From: Plant, Tom - Communities <Tom.Plant@Oxfordshire.gov.uk>
Sent: 05 September 2019 11:58
To: Bob Neville
Cc: DC Support; Councillor Kieron Mallon
Subject: 19-01056-F - Barn And Land South West Of Cotefield Farm Church Street Bodicote

Planning application: 19/01056/F
Location: Barn And Land South West Of Cotefield Farm Church Street Bodicote
Description: Erection of garage adjacent to approved dwelling and change of use of land to residential
Type: Full Development
Case Officer: Bob Neville

DRAWING NUMBER:
4728/21D

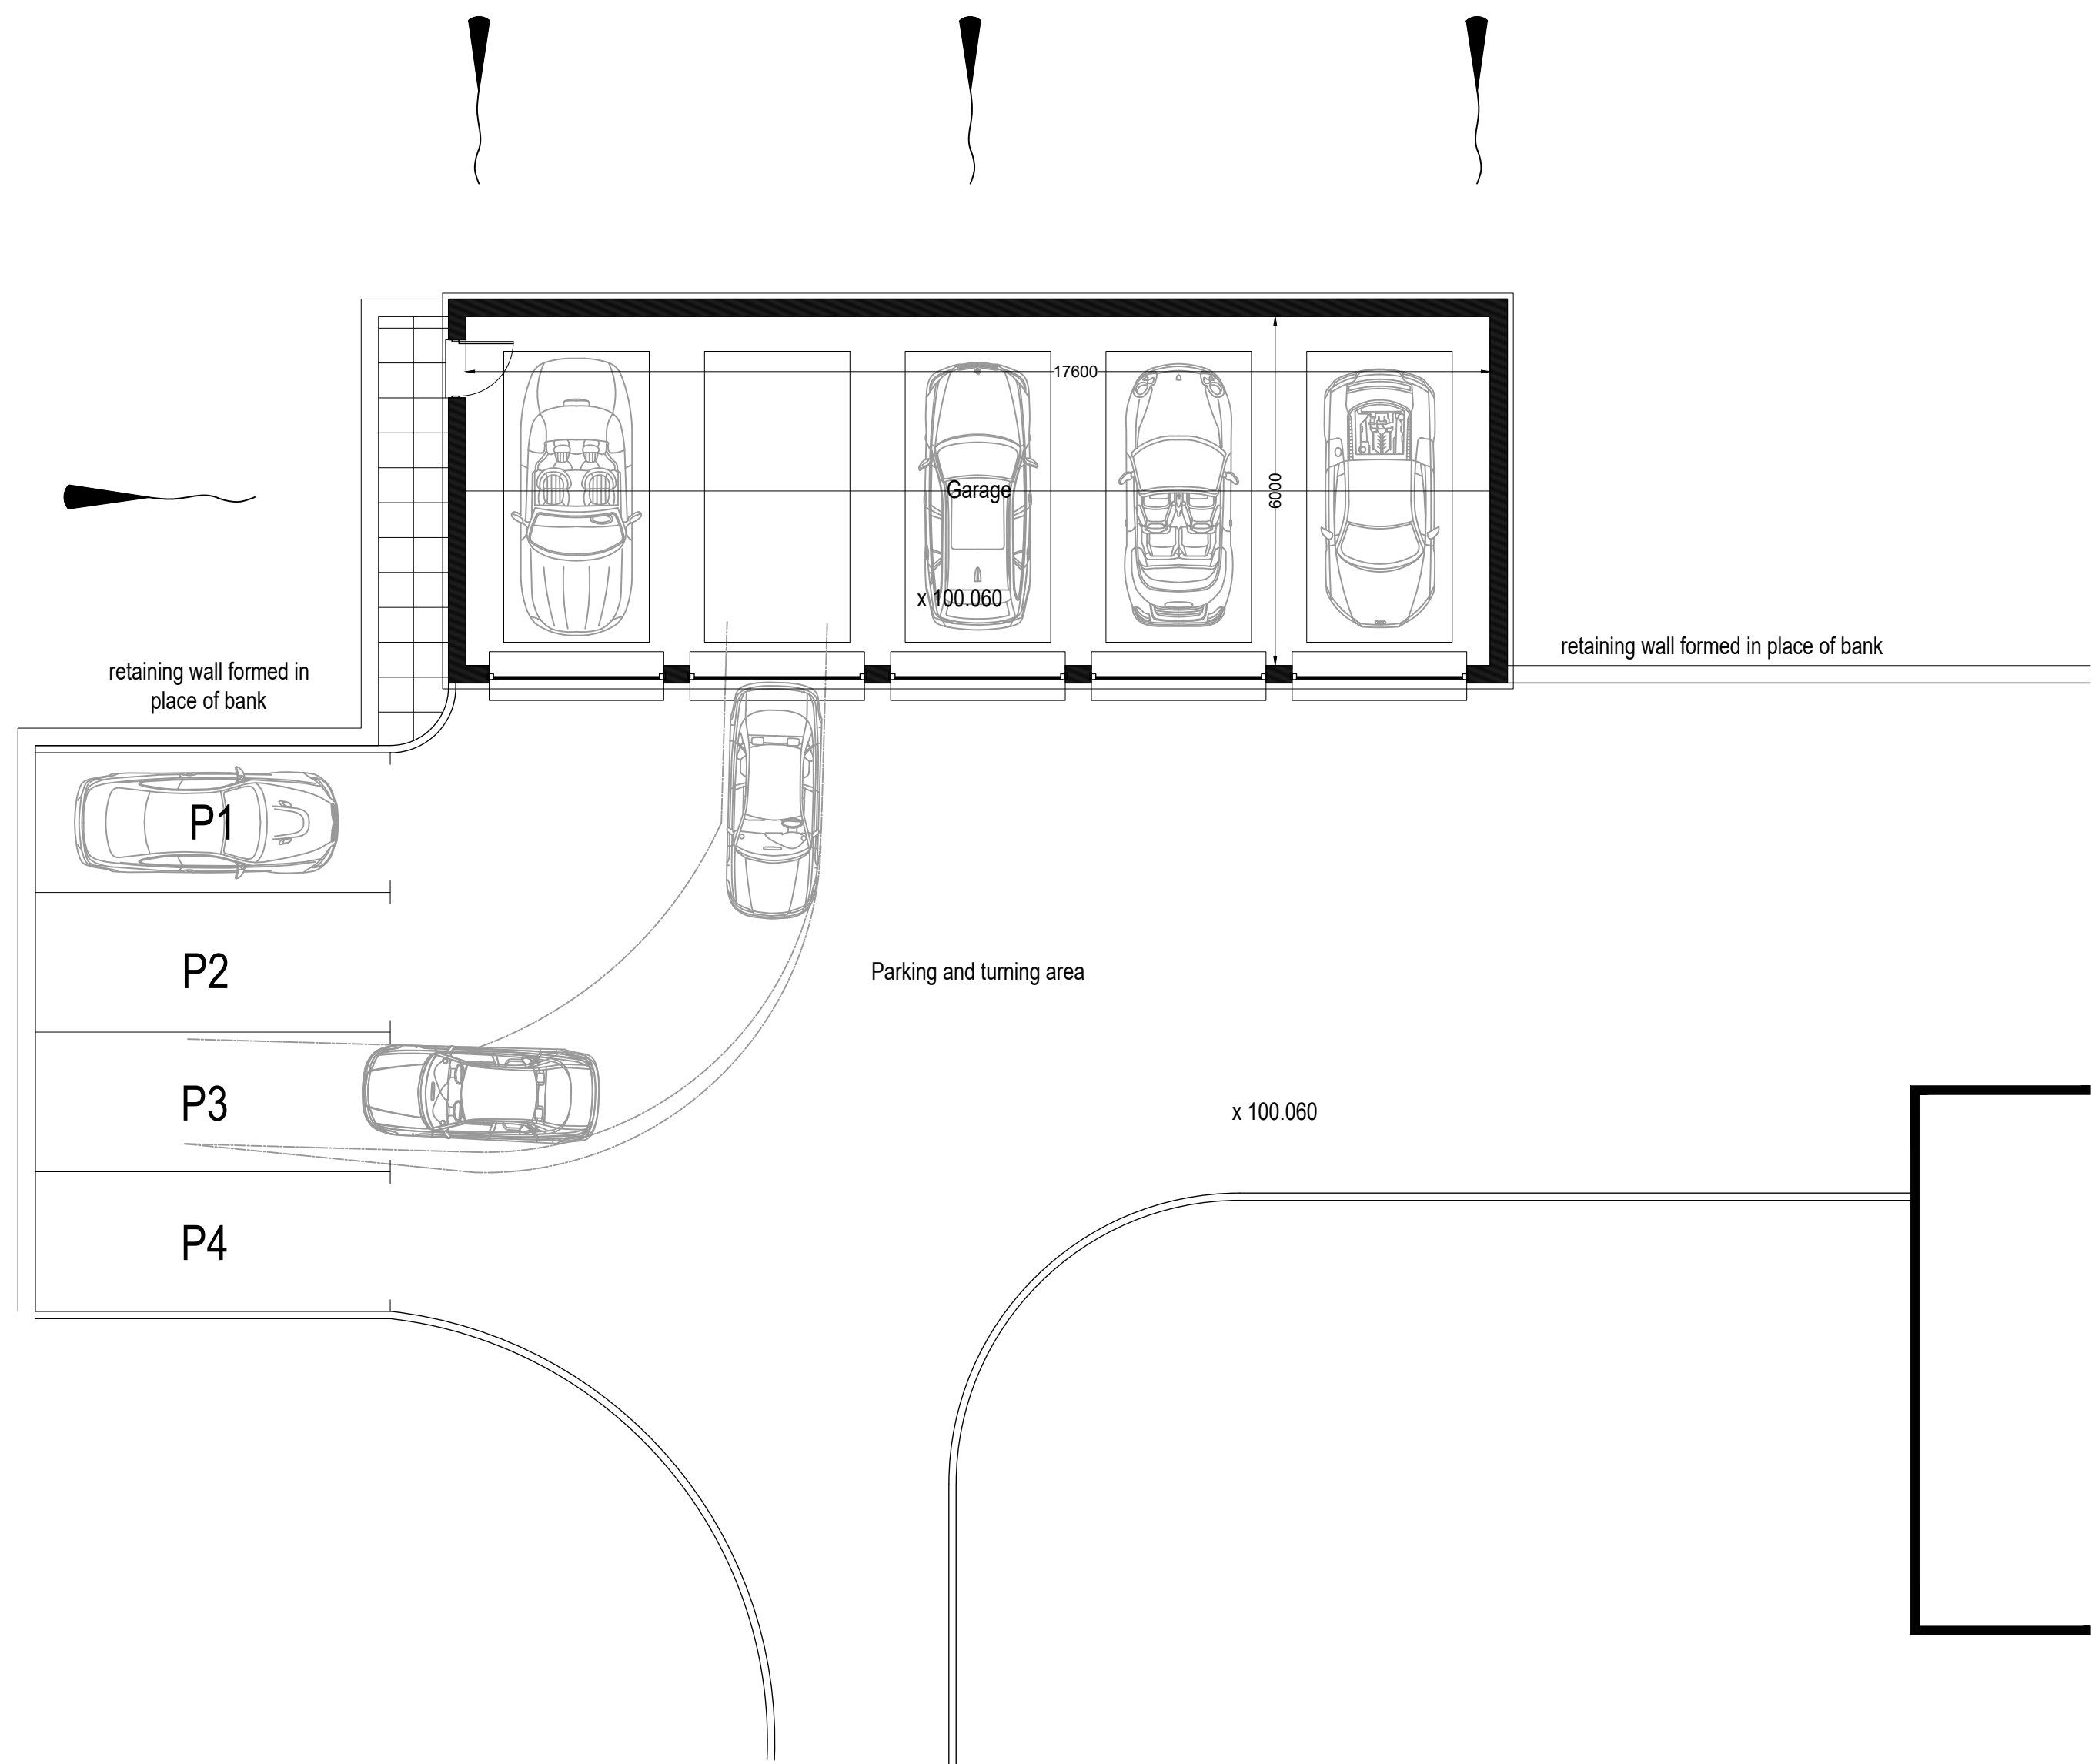
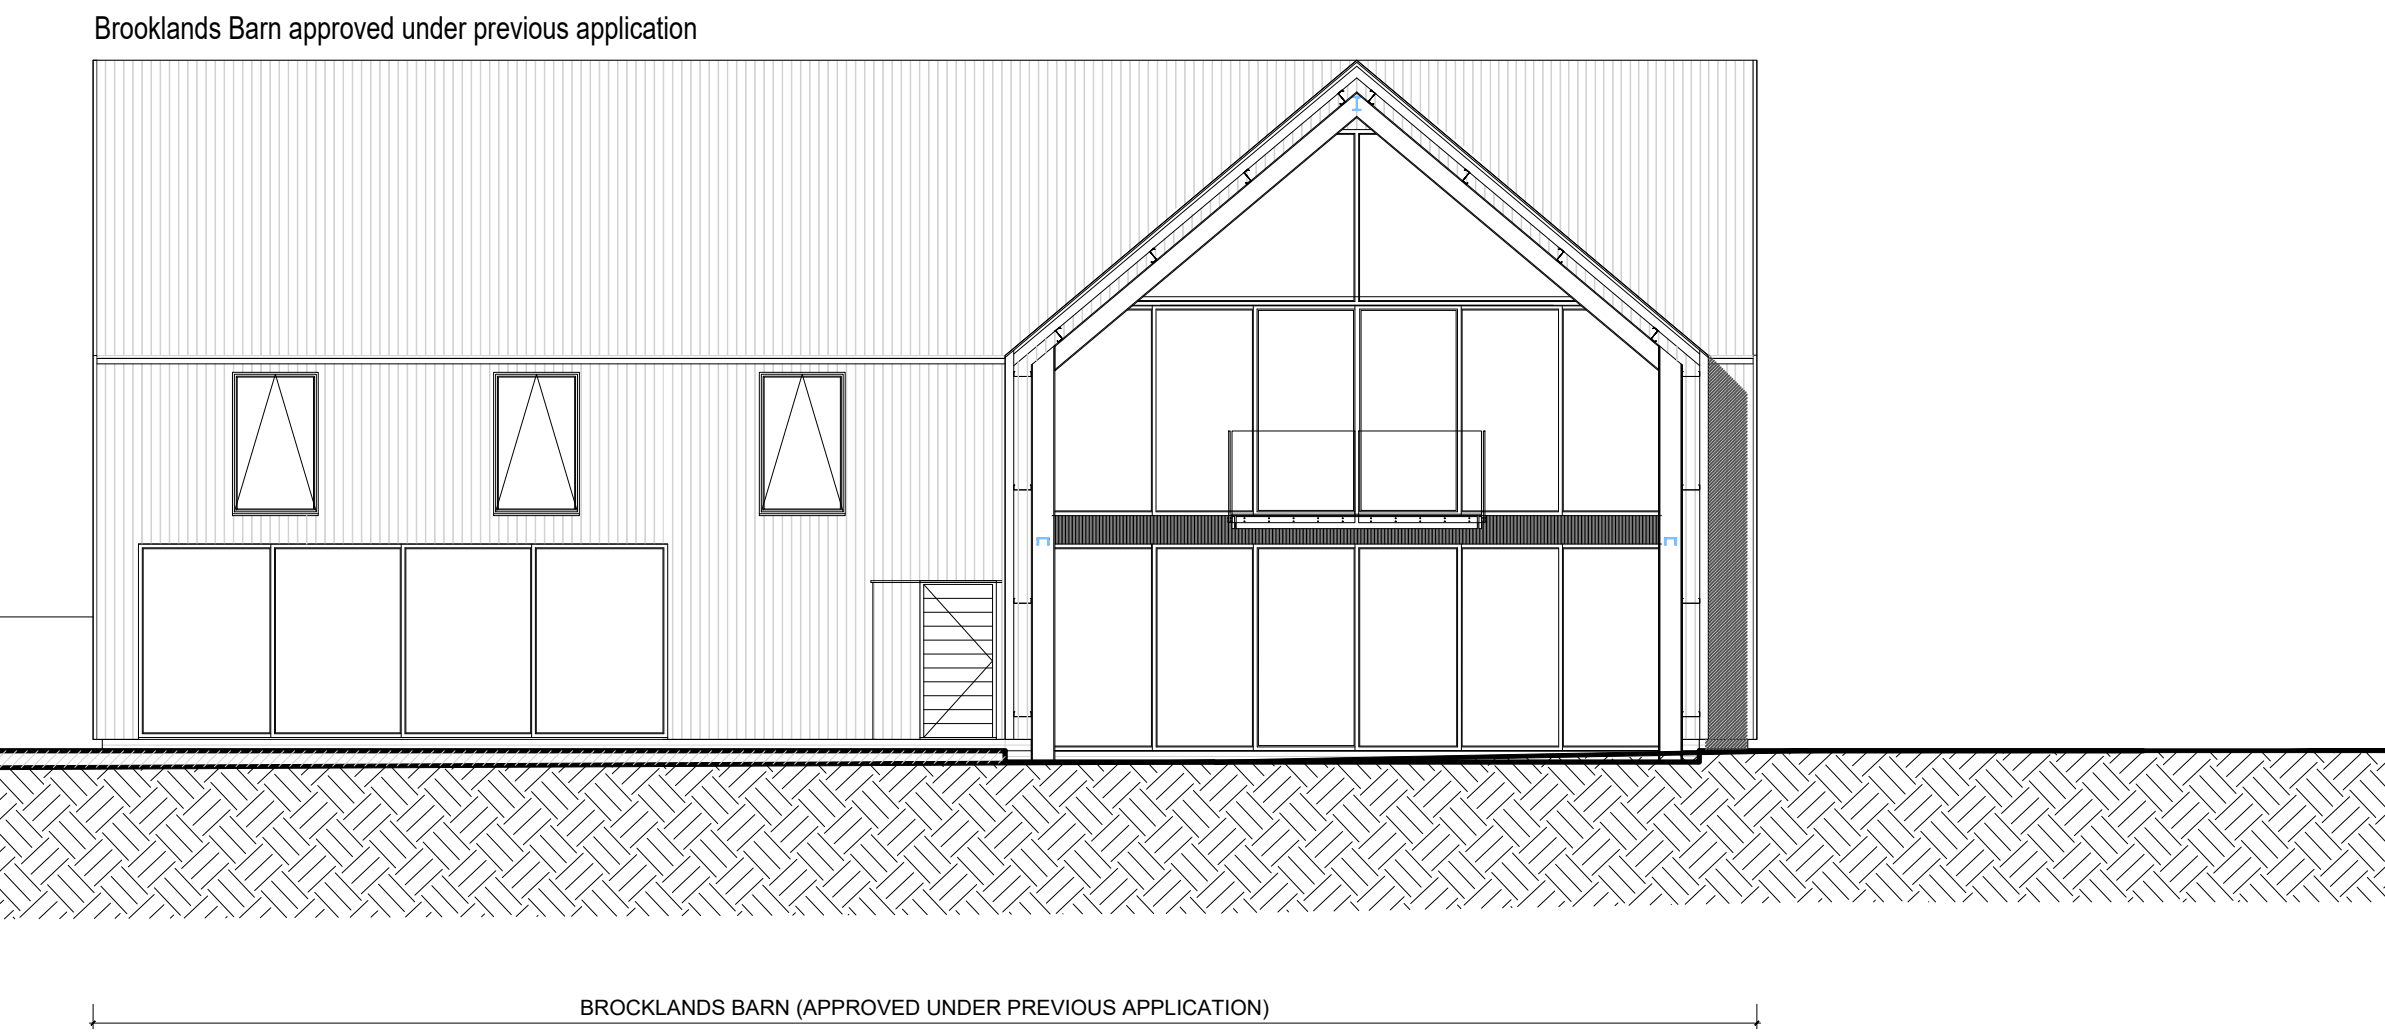
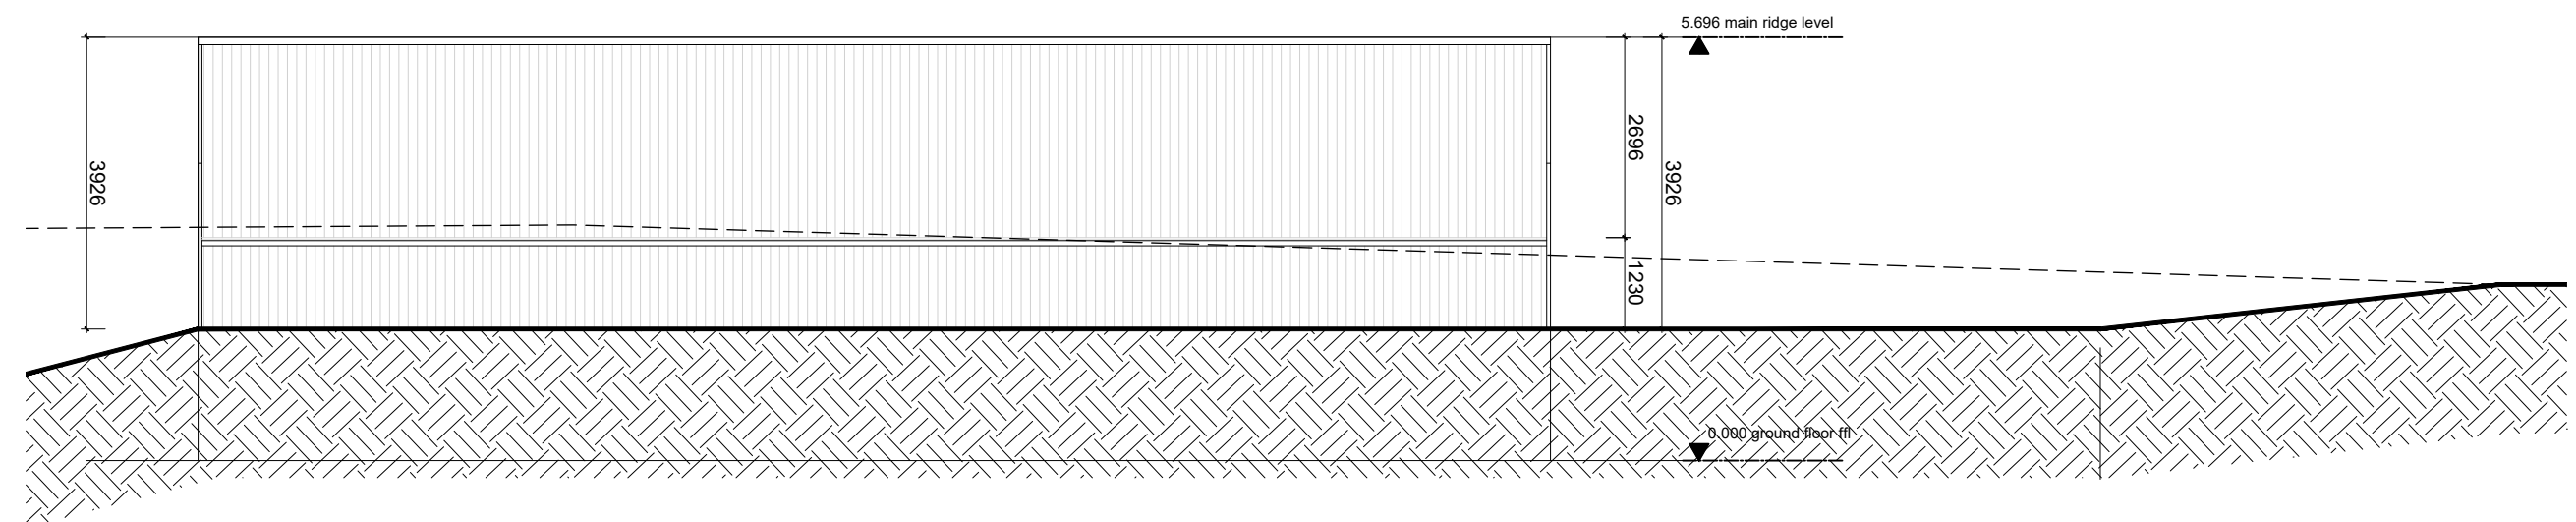
Prior to the first use/occupation of the development hereby approved, the parking and manoeuvring areas shall be provided in accordance with the plan approved (Drawing No. 4728/21D) and shall be constructed from porous materials or provision shall be made to direct run-off water from the hard surface to a permeable or porous area or surface within the curtilage of the site. Thereafter, the parking and manoeuvring areas shall be retained in accordance with this condition and shall be unobstructed except for the parking and manoeuvring of vehicles at all times. Reason - In the interests of highway safety and flood prevention and to comply with Policies ESD7 and ESD15 of the Cherwell Local Plan 2011-2031 Part 1 and Government guidance contained within the National Planning Policy Framework.
